**MASTER DEVELOPMENT DRAINAGE PLAN FOR
LOT 1177 WOODMEN HILLS FILING #10
EL PASO COUNTY, COLORADO**

OCTOBER 2020

TNE Job No. 2015.00
County Job No. SKP-20-003

LOT 1177 WOODMEN HILLS FILING #10  
EL PASO COUNTY, CO  
EXISTING DRAINAGE MAP  
OCTOBER 2020

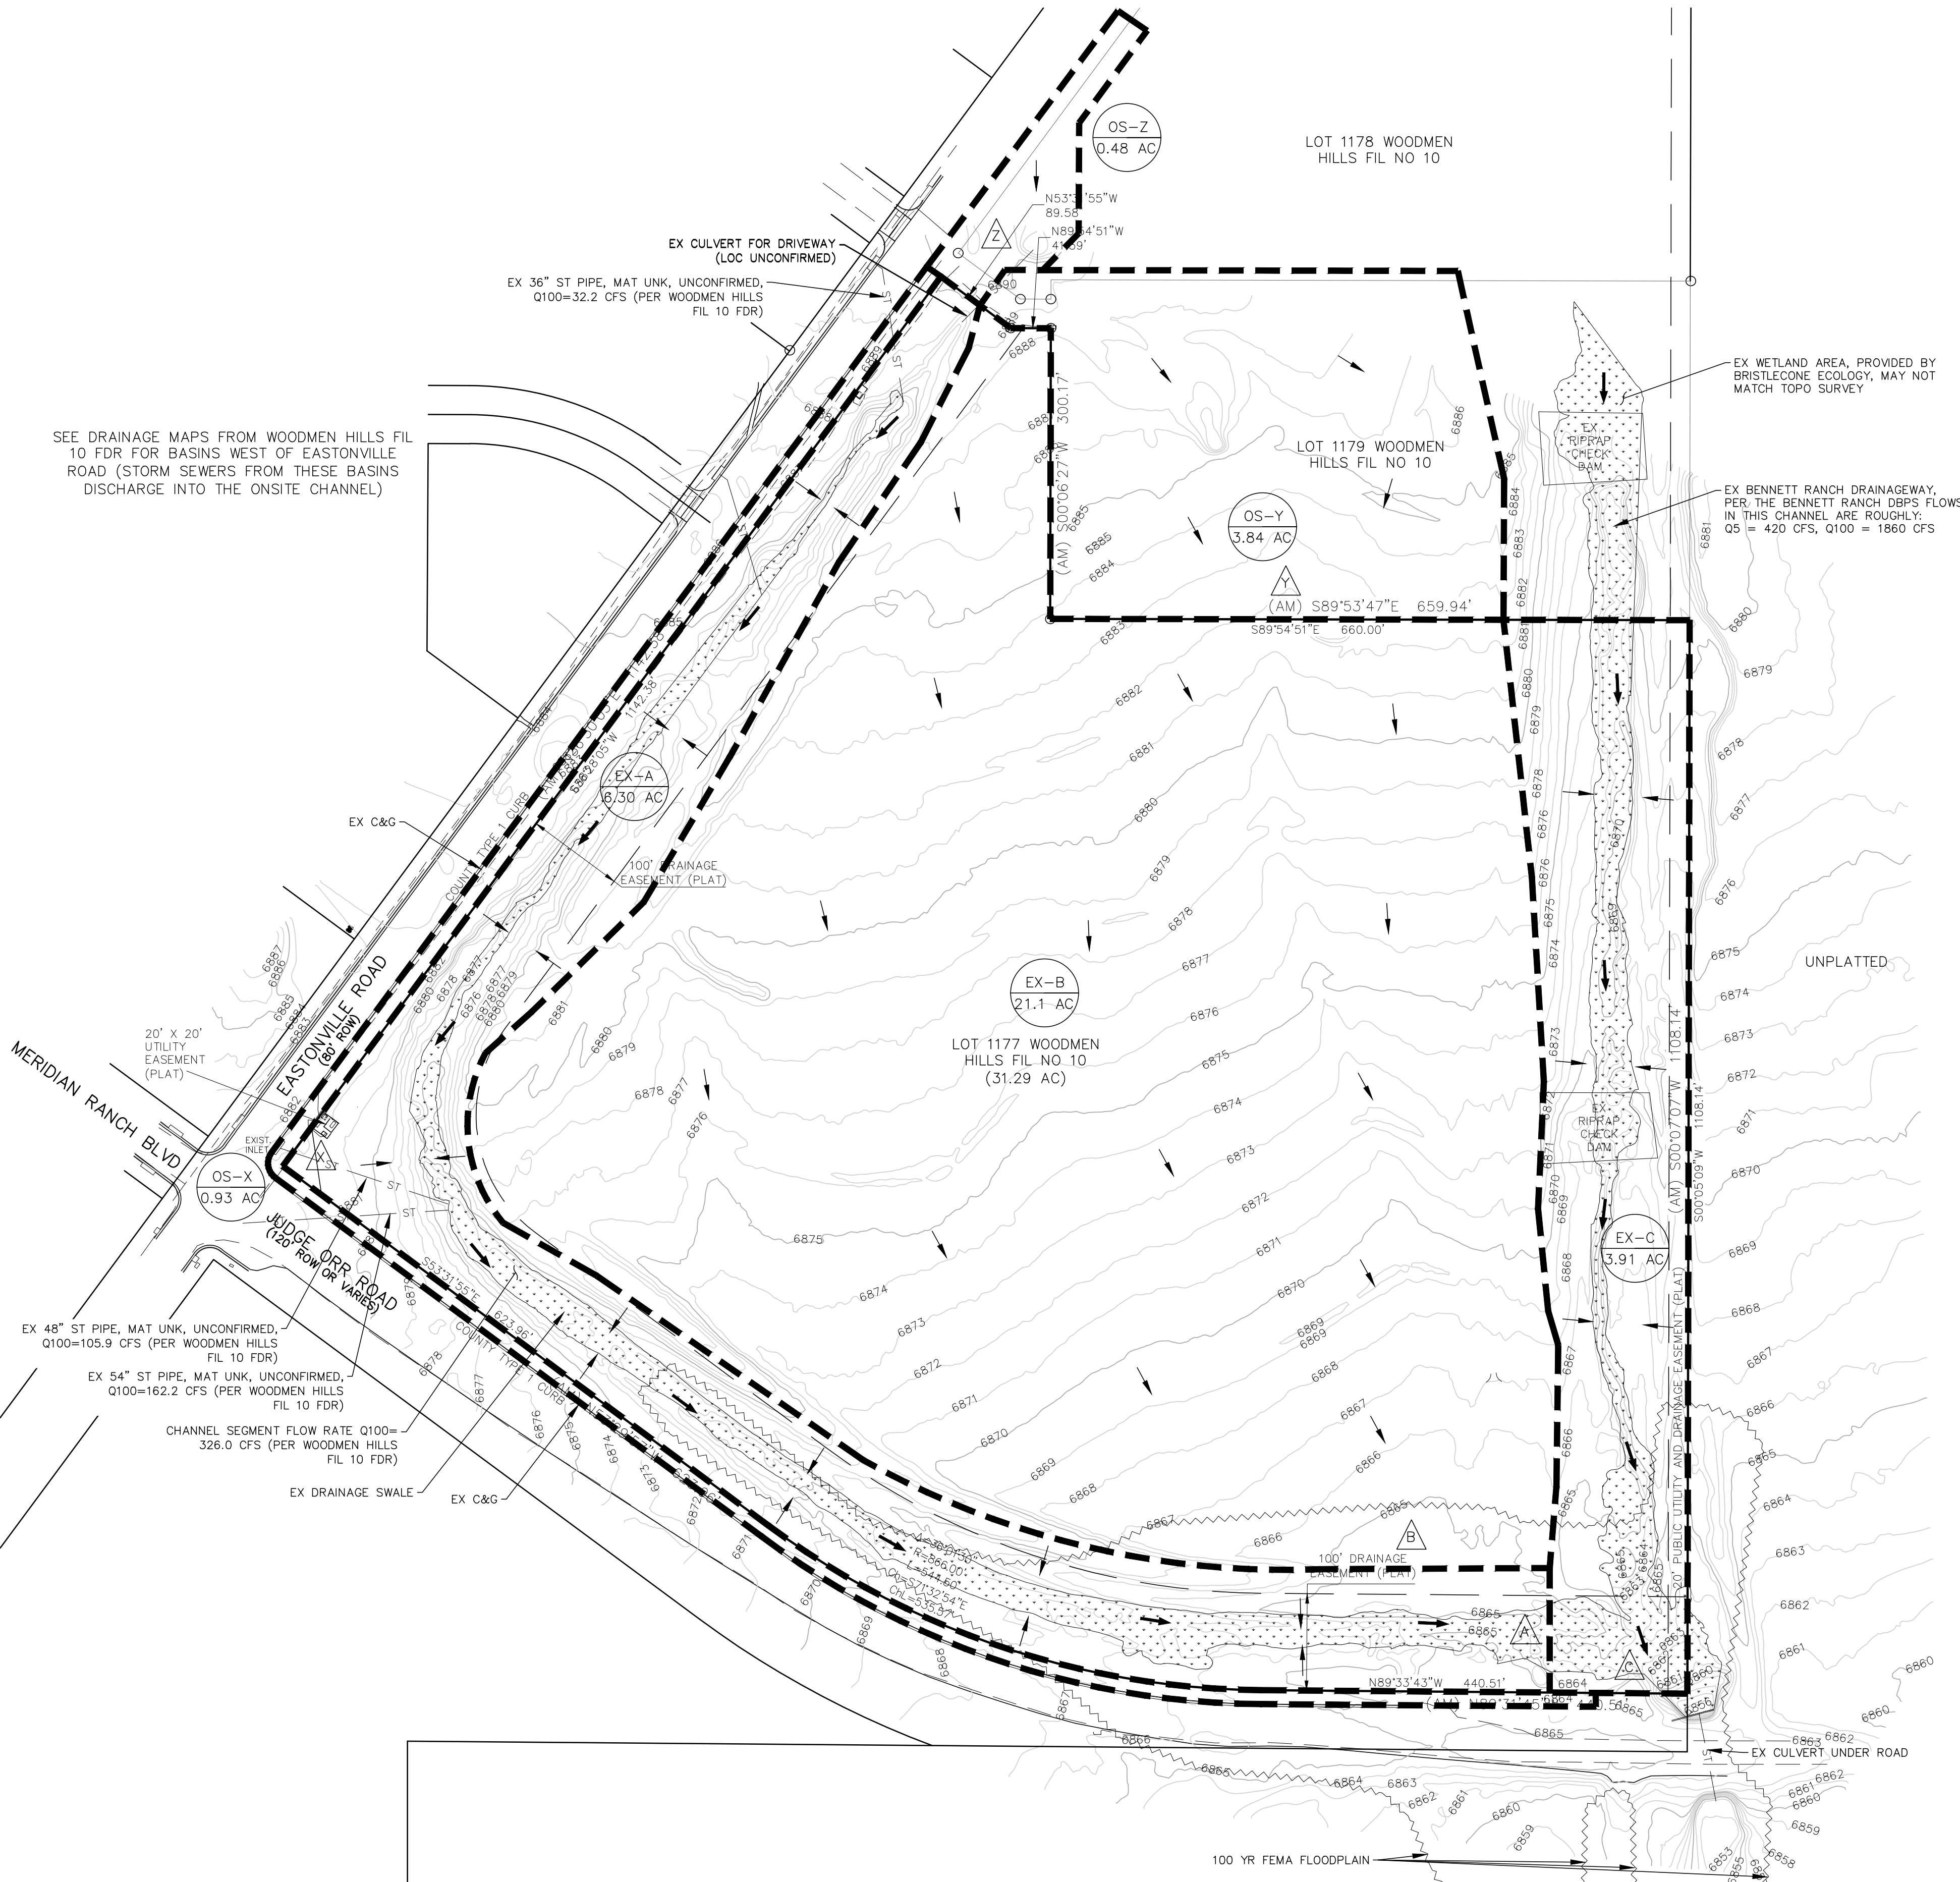
Please indicate in the narrative what these combined flows are.

Please provide excerpts of the portions of this report that describes the flow that is conveyed to these 4 storm sewers on this page. Otherwise describe in your narrative these offsite tributary areas/flows that are impacting your site.

Please elaborate on your discussion of the existing swale. What is the width of this swale, slope, V or trapezoidal, etc. Was this swale/channel designed/sized to convey these offsite flows and this sites flows?

Also please provide the flows(Q) that this swale is receiving from offsite areas in your narrative and also provide the cumulative flow in this basin(basin EX-A).

### PROPOSED DRAINAGE MAP

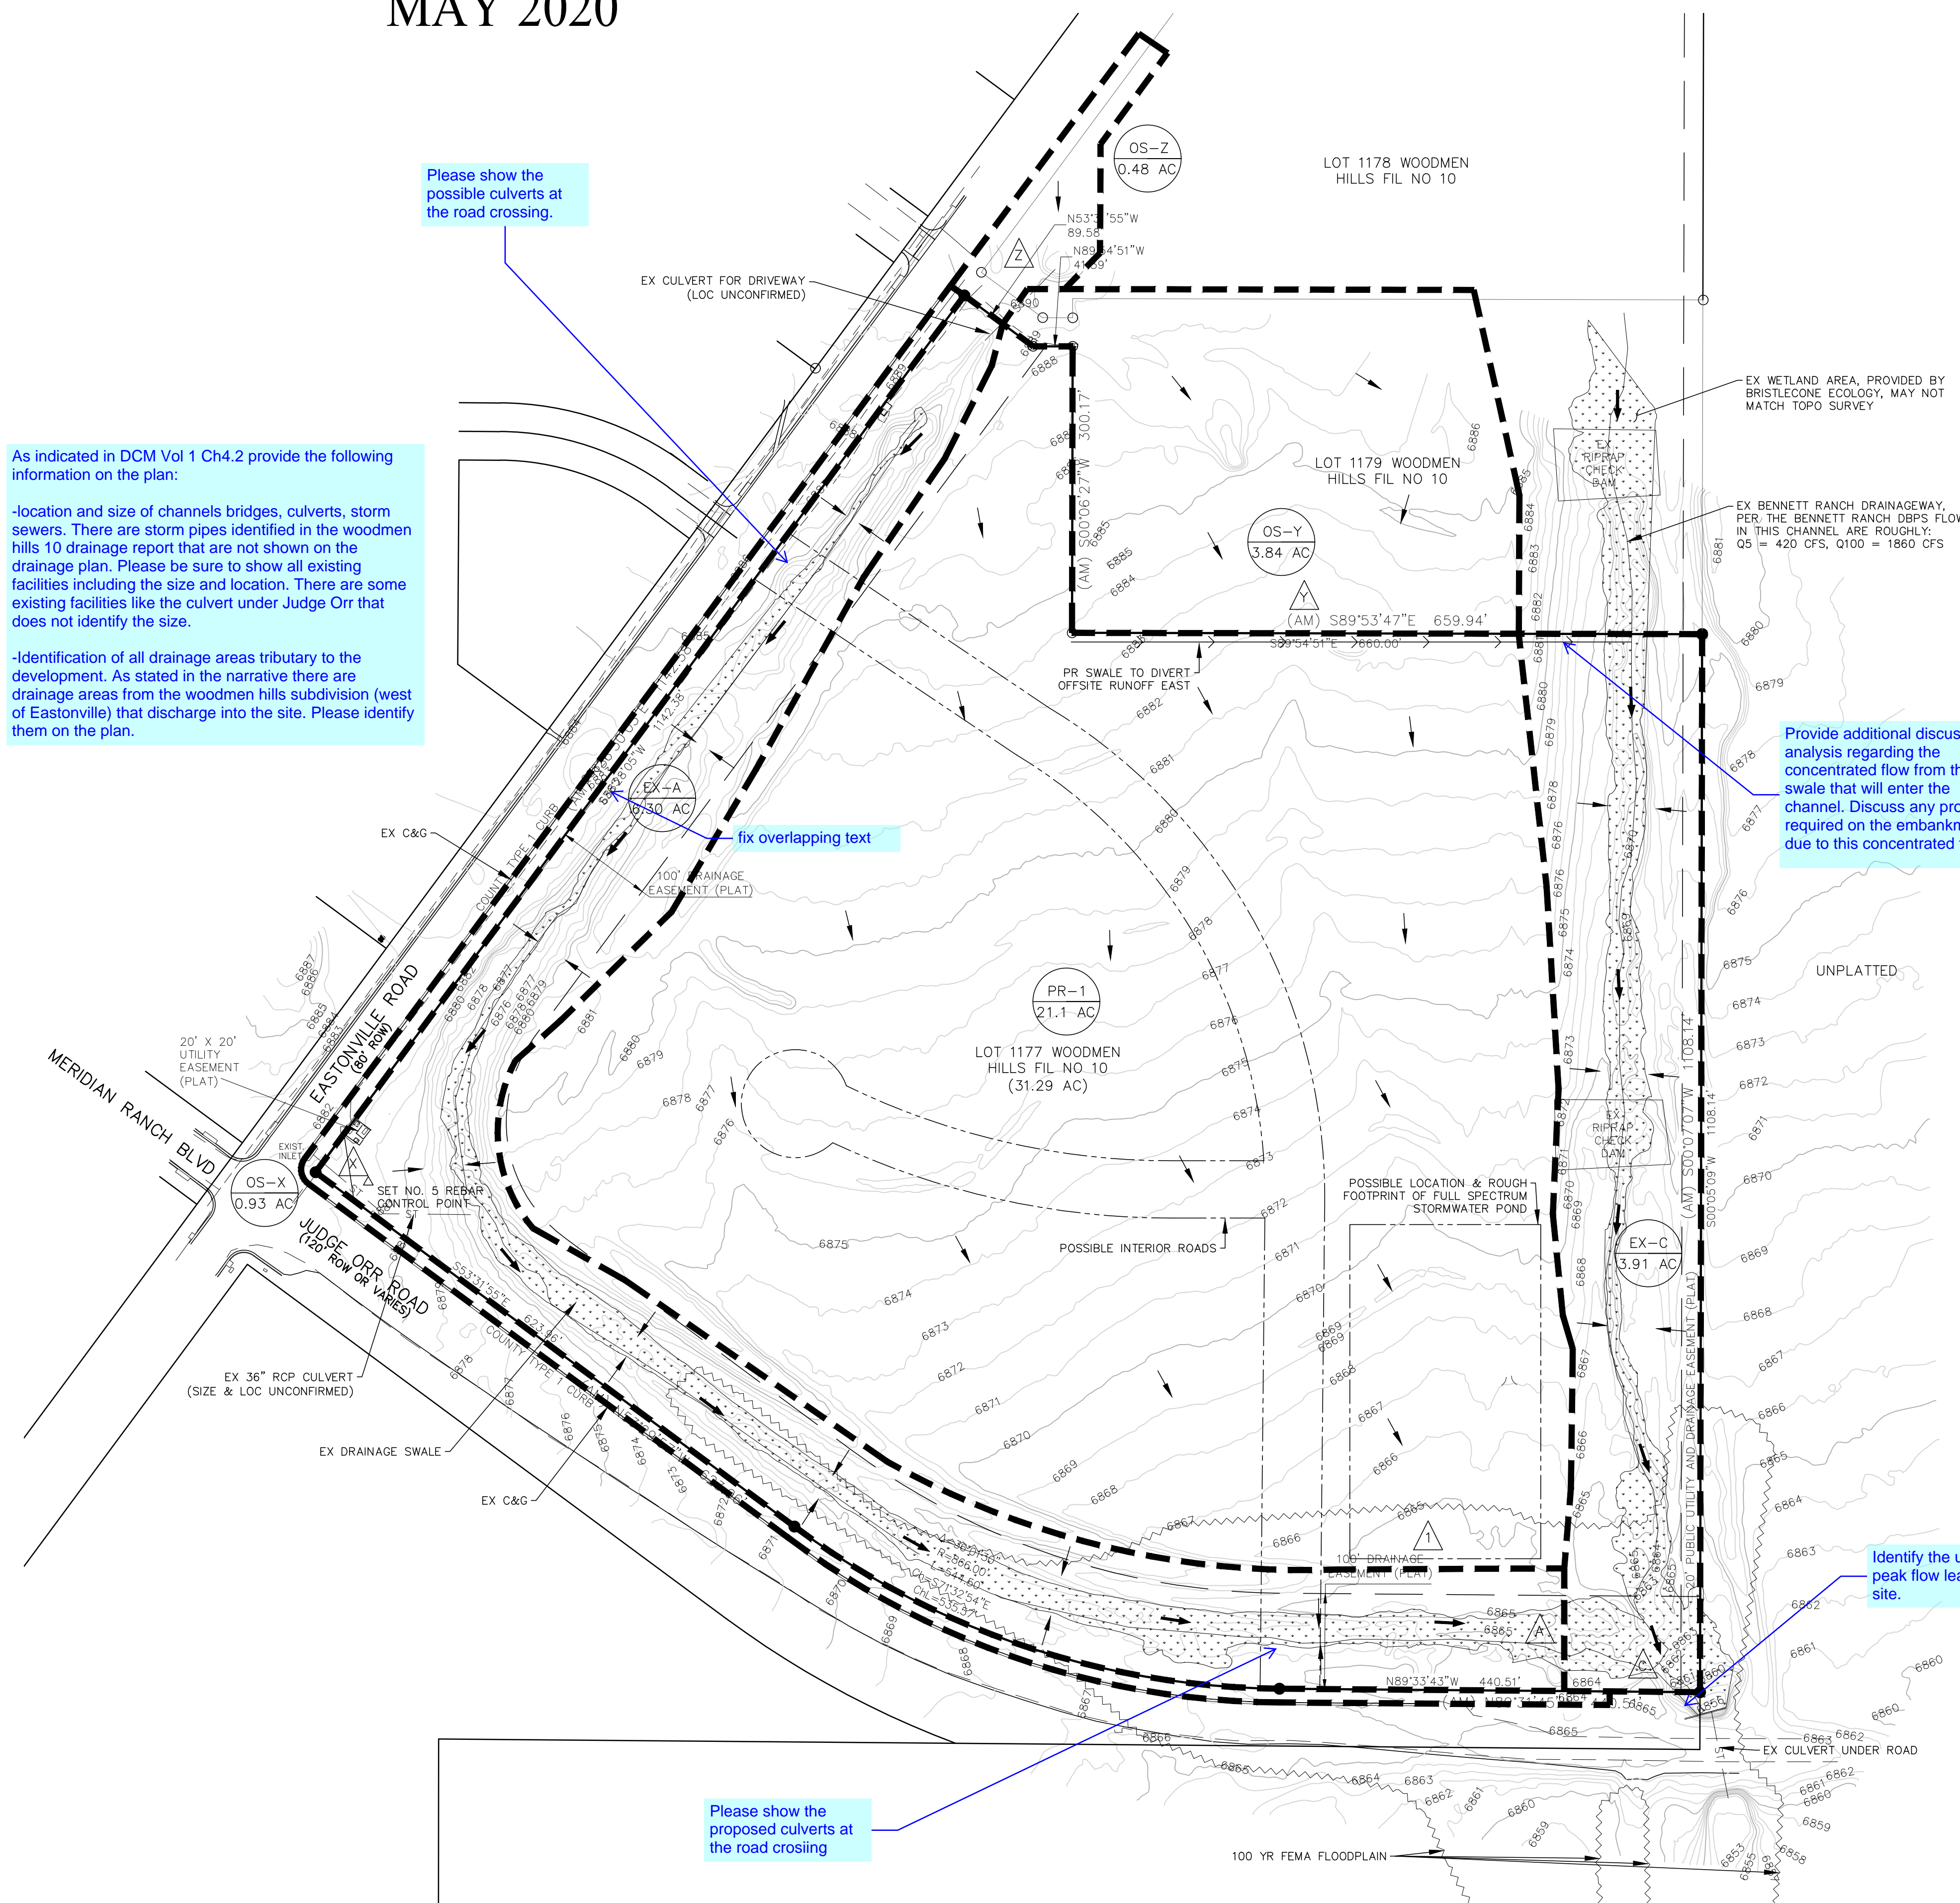
Please discuss the anticipated outfall of the pond as concentrated flow will outfall to either of the drainageways. Does the existing box culvert meet the definition of a suitable outfall location per ECM section 3.2.4.

It is not clear what those problems are from the text above. Please elaborate and clearly identify the anticipated drainage problems and solutions. This can be summarized in your conclusion.

based on your analysis of the existing drainageways is it anticipated that stabilization would be needed? you may also discuss any anticipated development to the swale/drainageway in this section. Please revise this section accordingly.
